MS T DANCE

WRITTEN REPRESENTATIONS

HIGHWAYS ENGLAND'S RESPONSE

Re; Project - M4 Junctions 3-12: Smart Motorway

Drawing title
ENVIRONMENTAL MASTERPLAN
REGULATION 4(2)(e)
SHEET 16 OF 61
MILL LANE UNDERBRIDGE

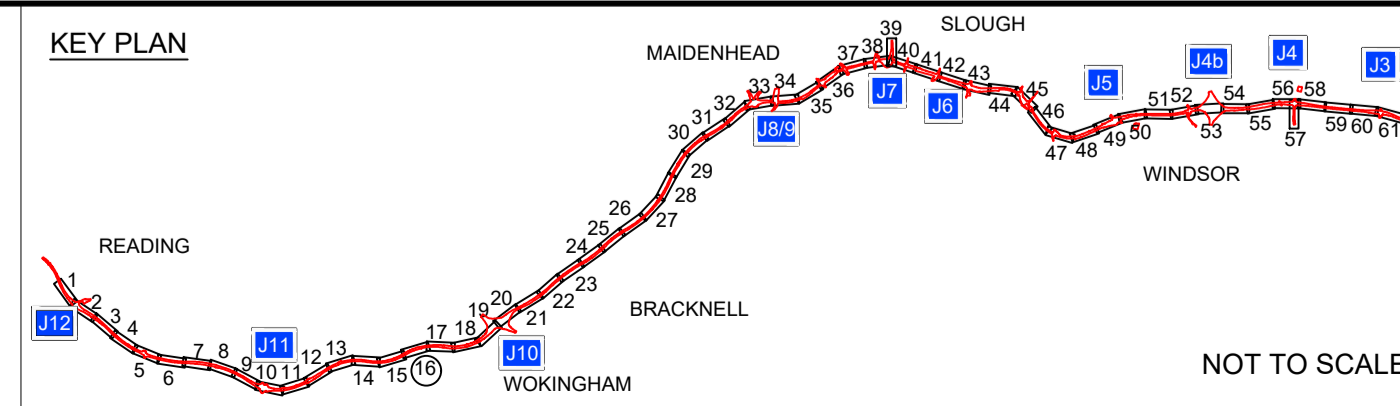
2.8 *I have estimated the position using drawing M4-PEIR_Drawing_04-1_Scheme-Plan_Sheet-01-19_J12-J10.pdf Sheet 16 and feel that it would mitigate the noise issue more effectively for*

us if the noise barriers were extended by a minimum 50m to the west on the E/B carriageway, from chainage 49150m to 49200m. In addition we feel the additional low-noise surfacing should also be extended by a minimum of 50m, again on the E/B carriageway from chainage 49140m to 49190m. – It is my understanding that it is now intended to lay low-noise surfacing throughout the scheme.

- 2.14 *A mitigation that we feel would prevent this would be to raise the Noise Barrier from the 2m height mentioned under item 12.6.10 (Page 12.36) to 2.4m in height to give us the visual privacy that we should enjoy in our properties reducing the likelihood of truck drivers/passengers being able to see into our properties.*

- 2.8.1 It is confirmed that low noise surfacing across all lanes, along the complete extent of the Scheme, will be provided.
- 2.8.2 The proposed noise mitigation for the Scheme is discussed in Section 2.6 above. As addressed in paragraph 2.6.7 above, these properties on Mill Lane will experience noise reductions with the Scheme in operation with the proposed mitigation and therefore there is no need to extend these noise barriers by 50m to mitigate the effects of the Scheme

- 2.8.4 A quantitative assessment of this enhanced mitigation strategy is currently being carried out (the barriers at Mill Lane form part of this enhanced mitigation strategy). The quantitative assessment is based on a detailed cost / benefit analysis, the outcome of which will determine whether additional barriers (or replacement barriers) are provided to specific areas along the Scheme. The results of that assessment, and the results of the assessment of the landscape and visual impact of any additional noise barriers proposed, will be provided to the Examination in due course.

- 2.14.1 As stated in the response to paragraph 2.6, it is anticipated that the Scheme will result in a slight adverse effect on the property's visual amenity and a limited change in privacy when compared to the present situation. On this basis the effects reported in the ES on visual amenity would not warrant an increase in the height of the proposed noise barrier.
